## ***Rezoning Petition Review***

**Date of Review:** August 21, 2017 ***(Revised March 12, 2021)***

**Rezoning Petition #:** 17-118

**Location of Property:** Approximately 0.78 acres located at the northwest corner at the intersection of Statesville Road and Cindy Lane.

DATE: 04/12/21  
FILE: MHP/PL  
DRAWN BY: RST  
REVISED:  
JOB NO: \_\_\_\_\_  
SHEET: **RZ-1**  
OF: \_\_\_\_\_

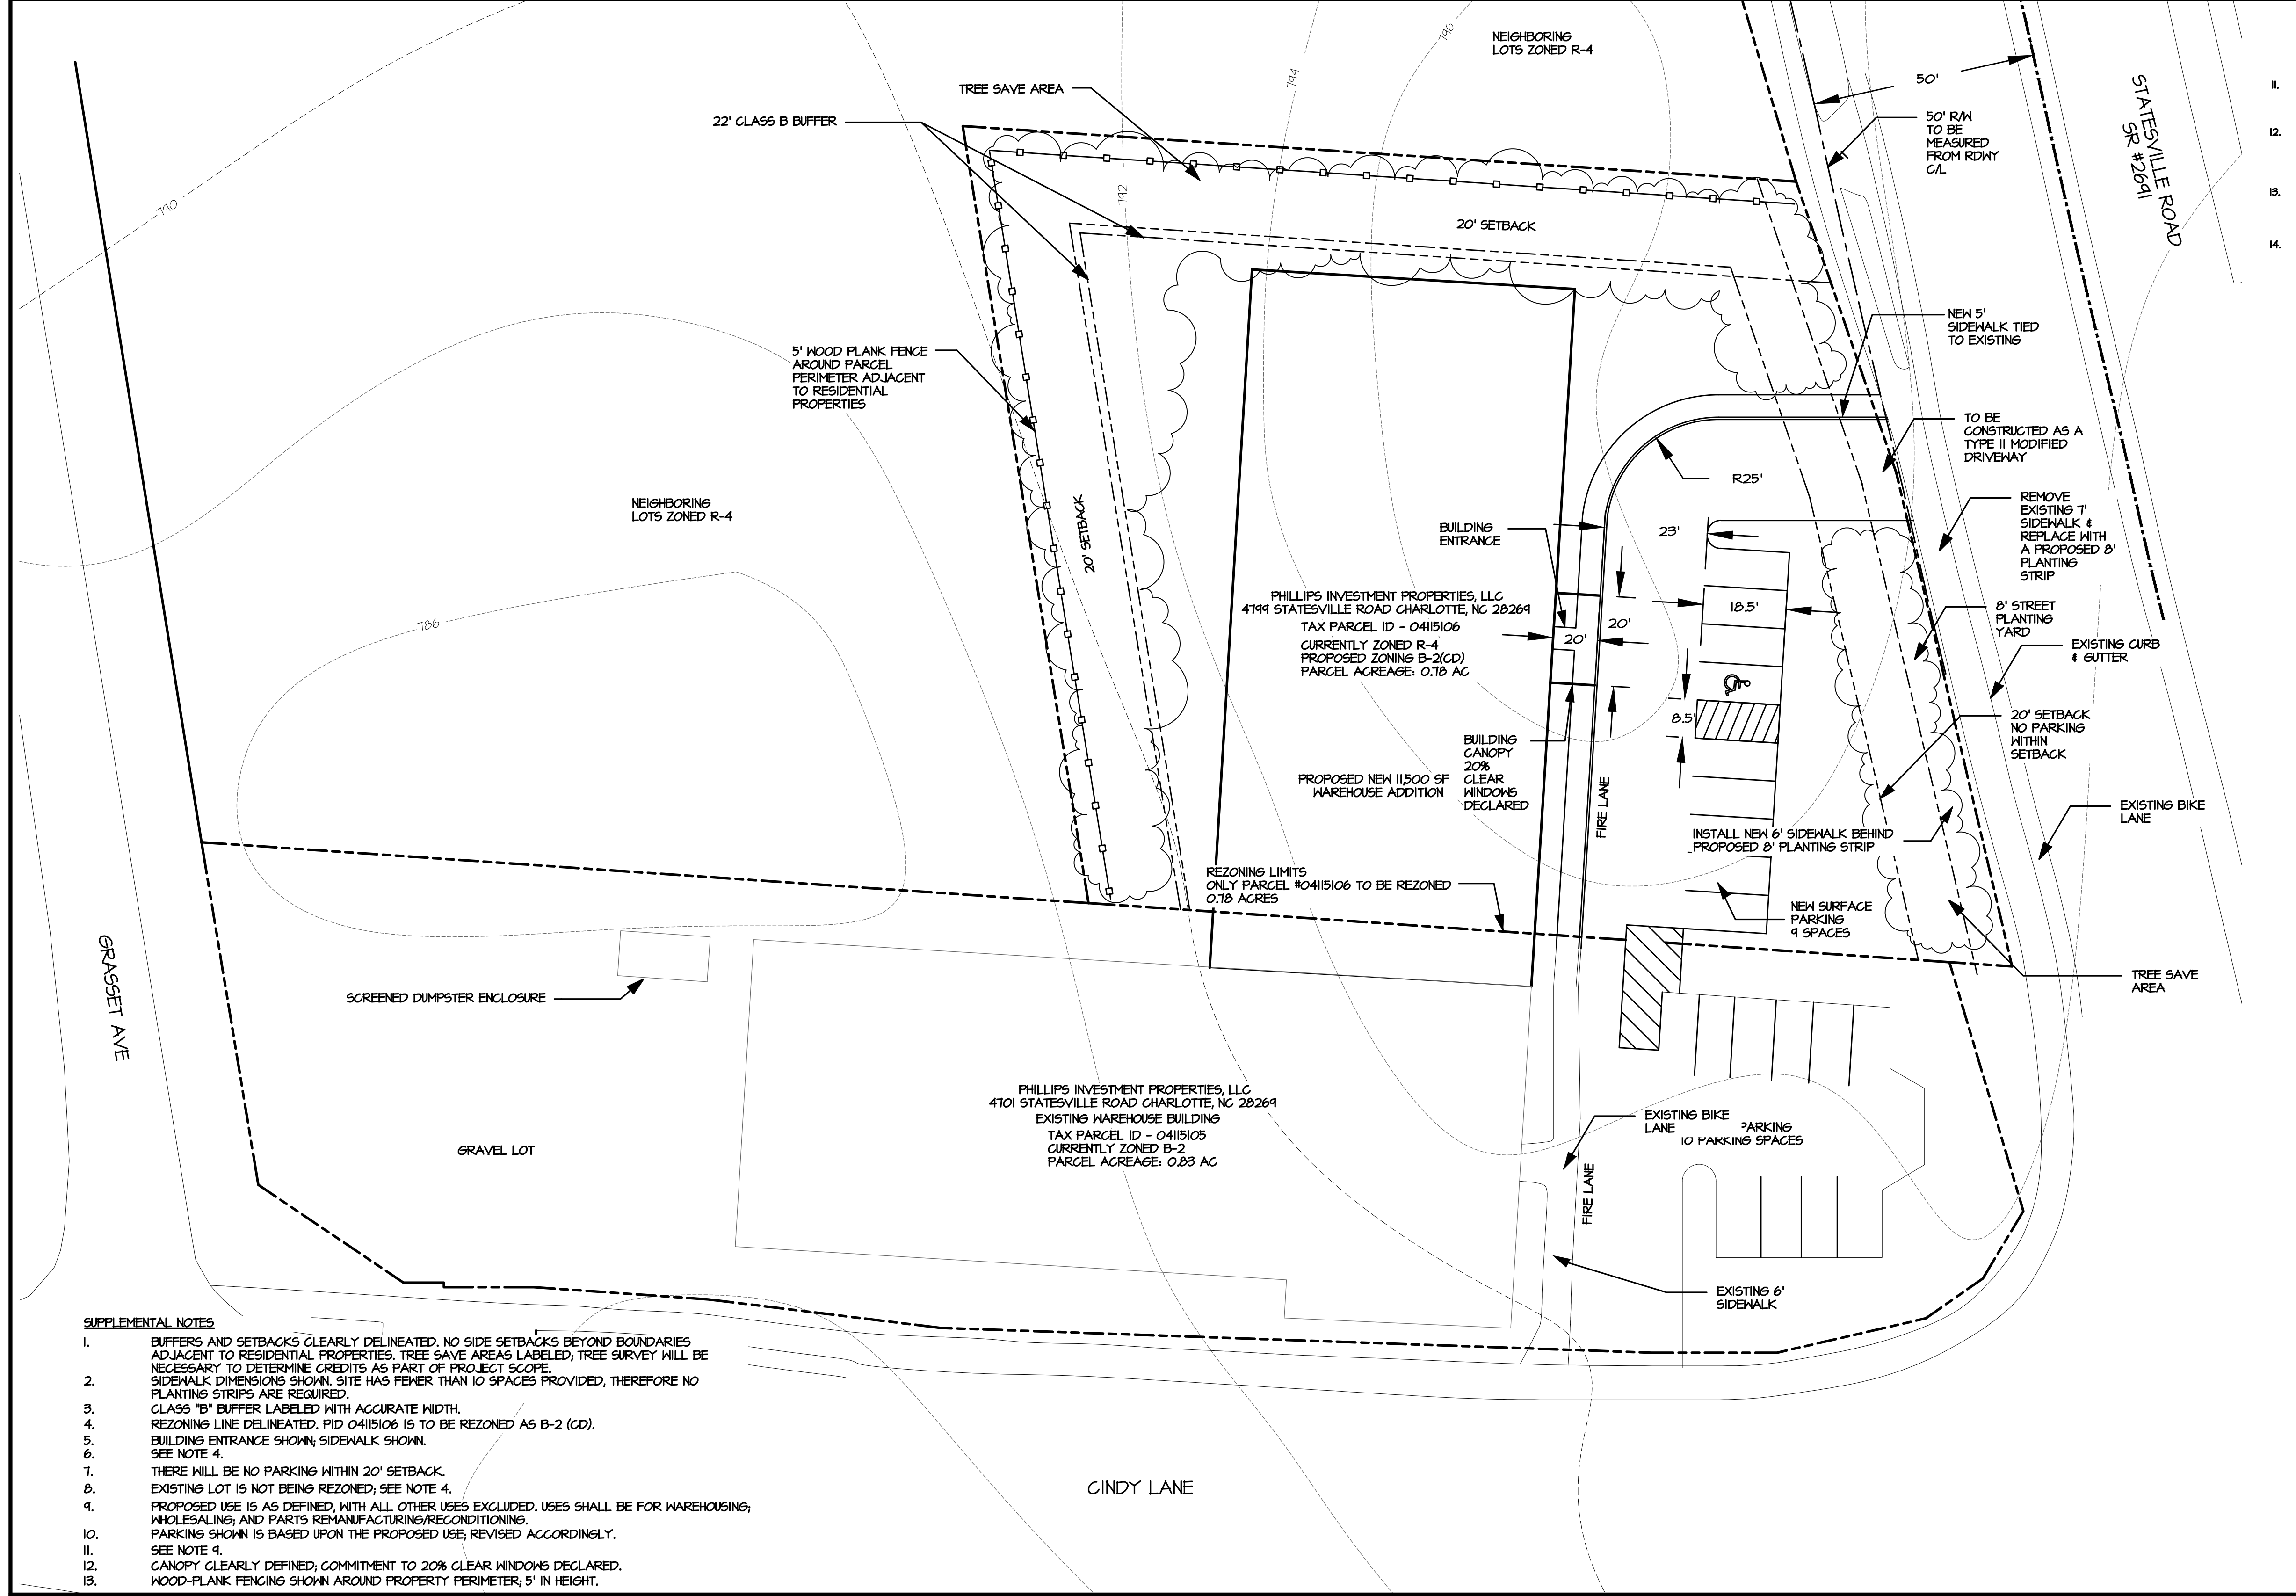
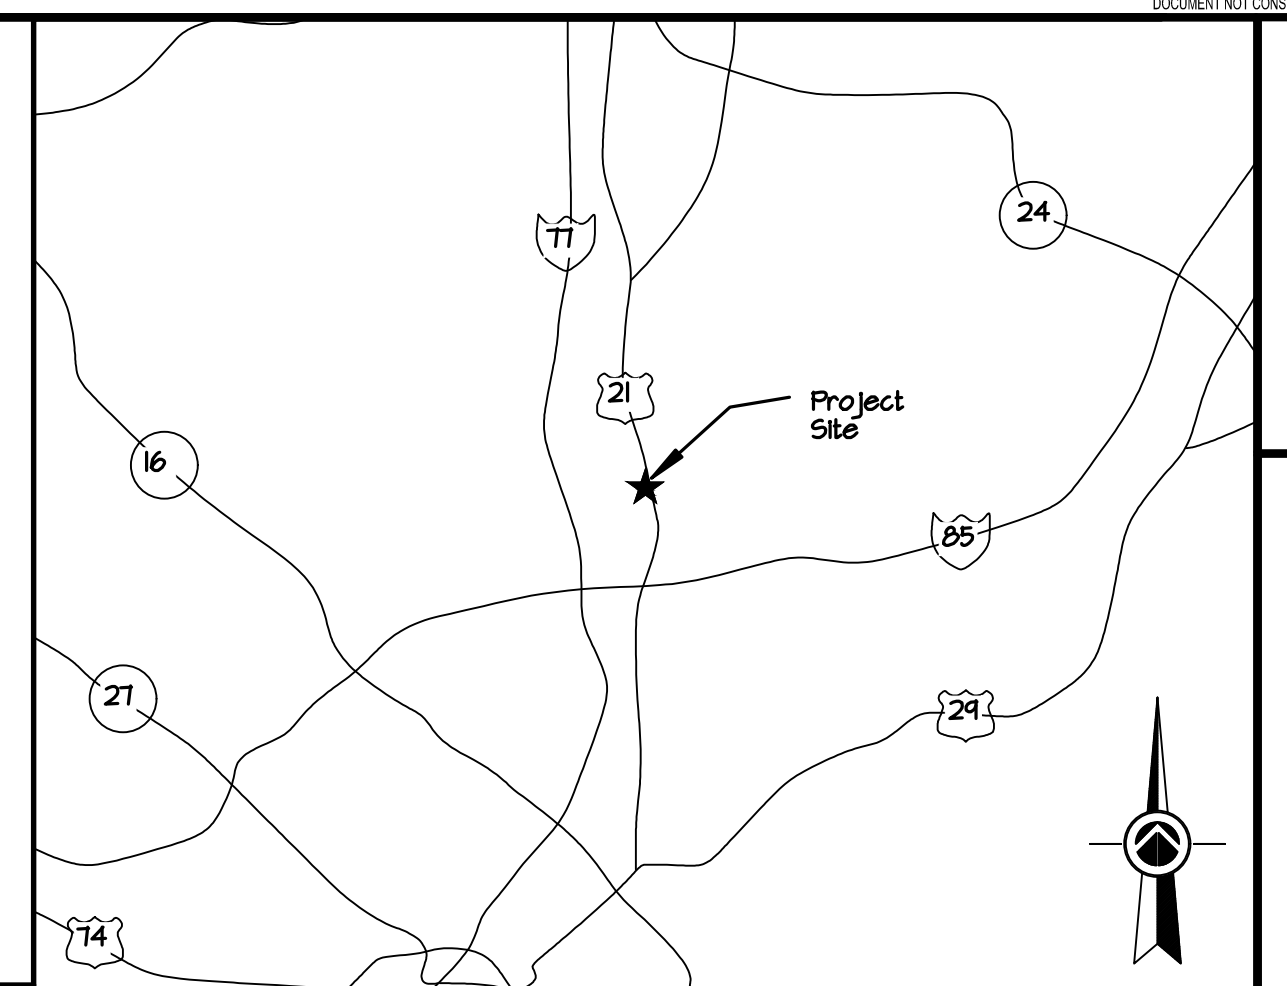
Please remove note 8b in its entirety and replace with the following: *"The petitioner shall comply with the Charlotte City Council approved and adopted Post Construction Stormwater Ordinance."*

DATE: 01/11/21
FILE: M21014
DRAWN BY: RST
REVISED:
JOB NO: _____
SHEET: RZ-1
OF: _____

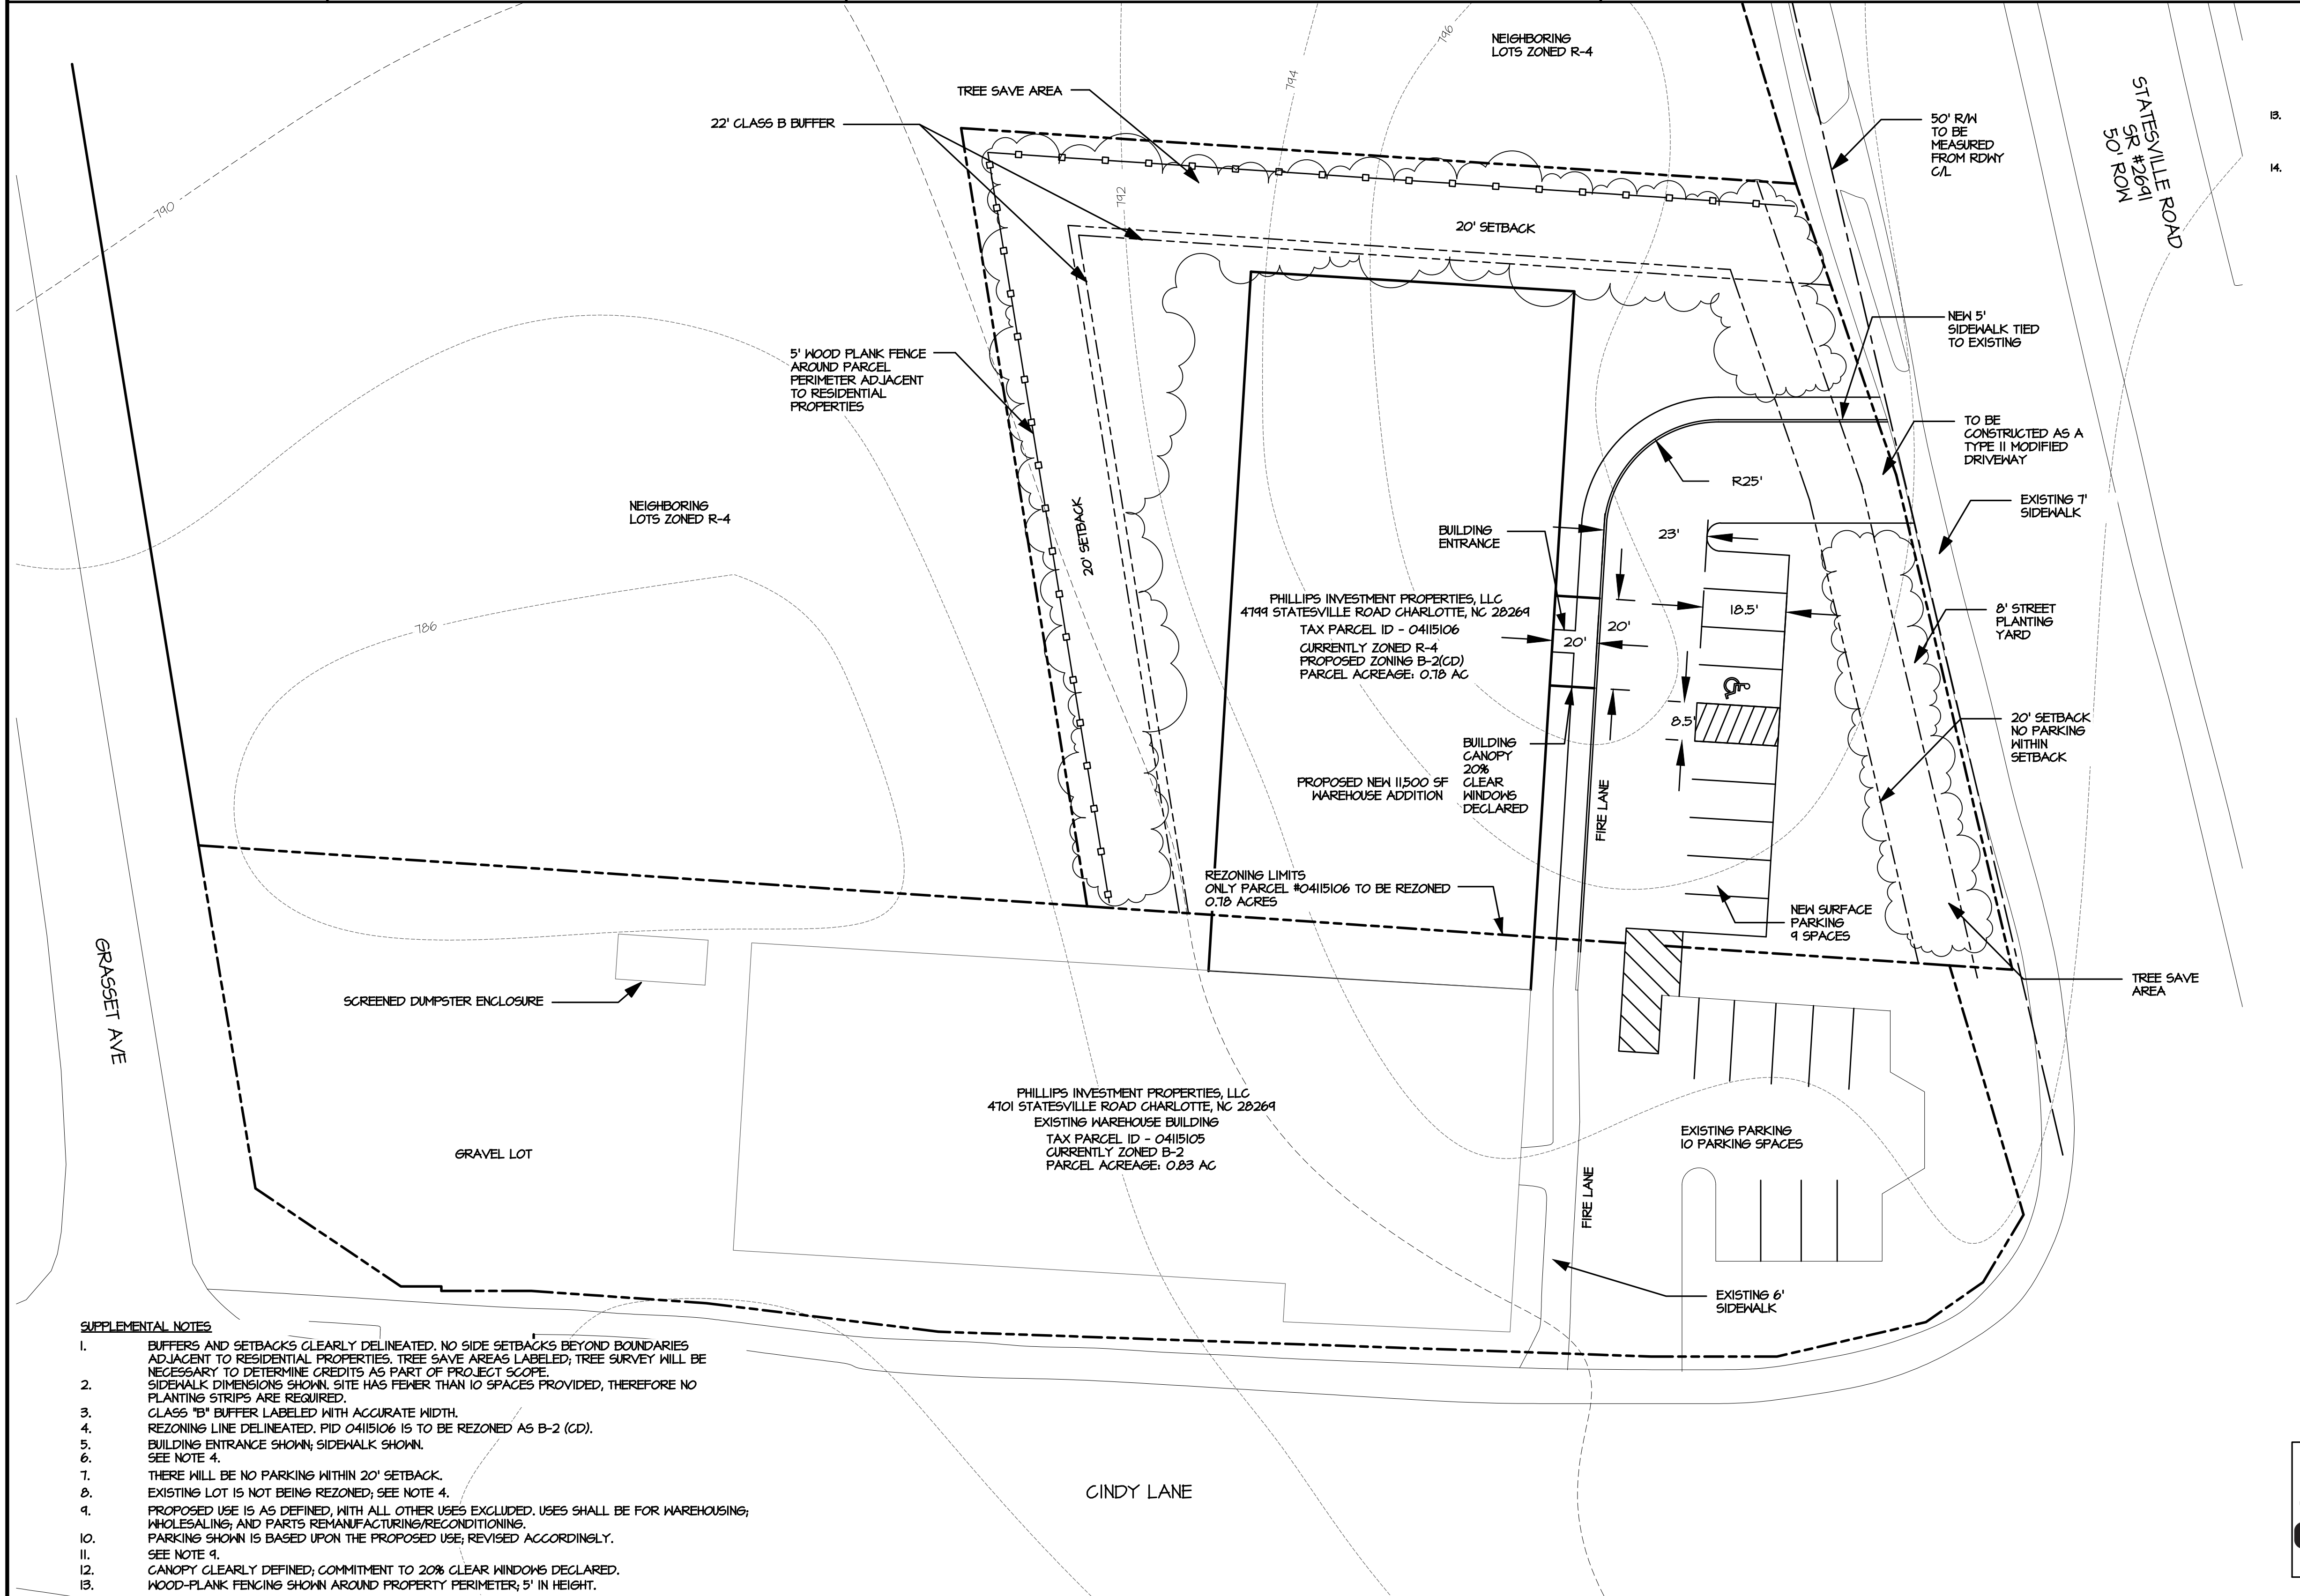
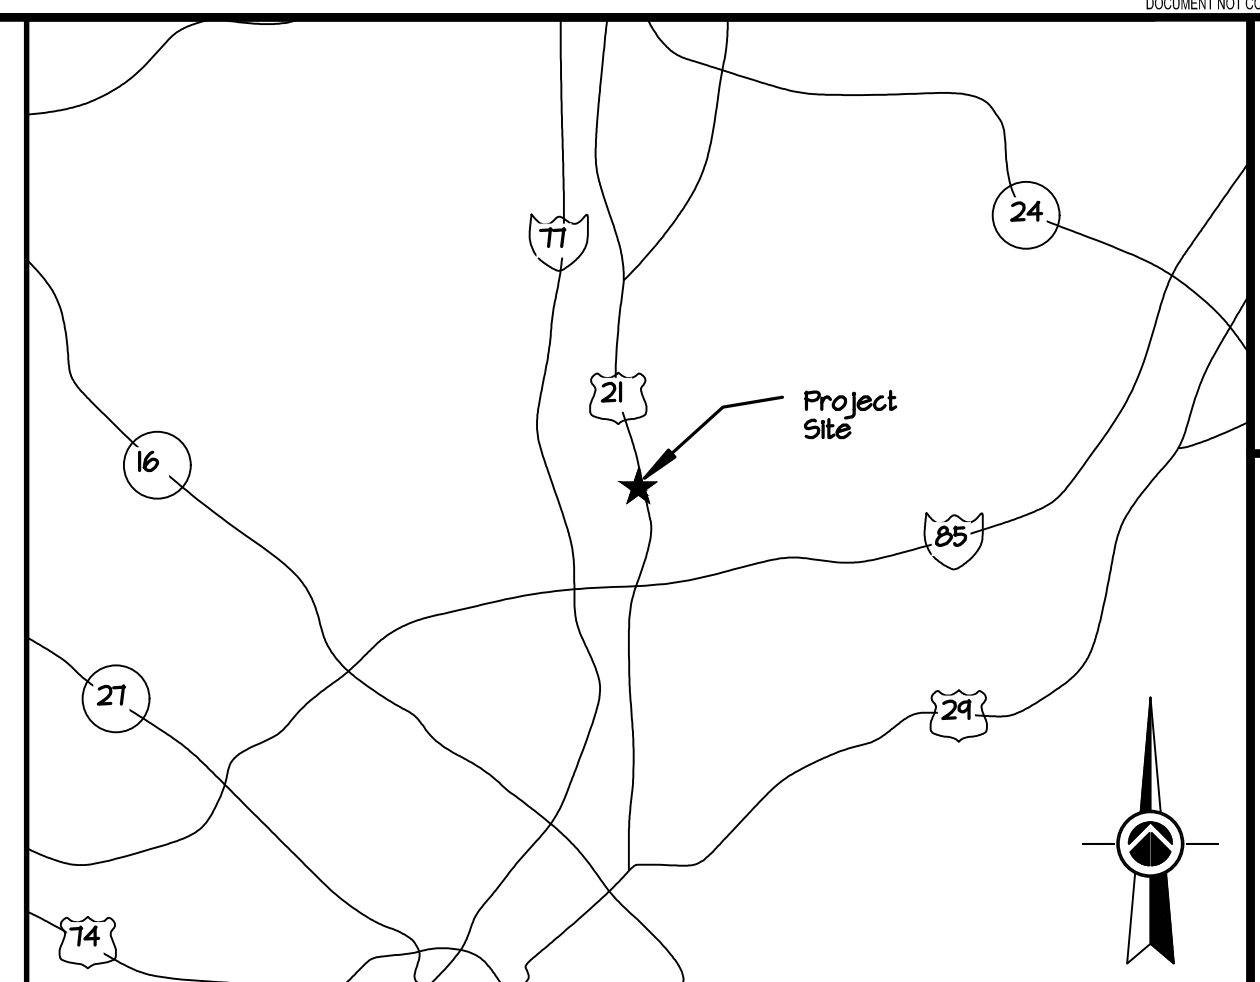
**Due to revisions (3/12/21):** Post Construction Stormwater Ordinance applicability is determined during the Land Development plan submittal and review process, and not during the rezoning request process and approval.
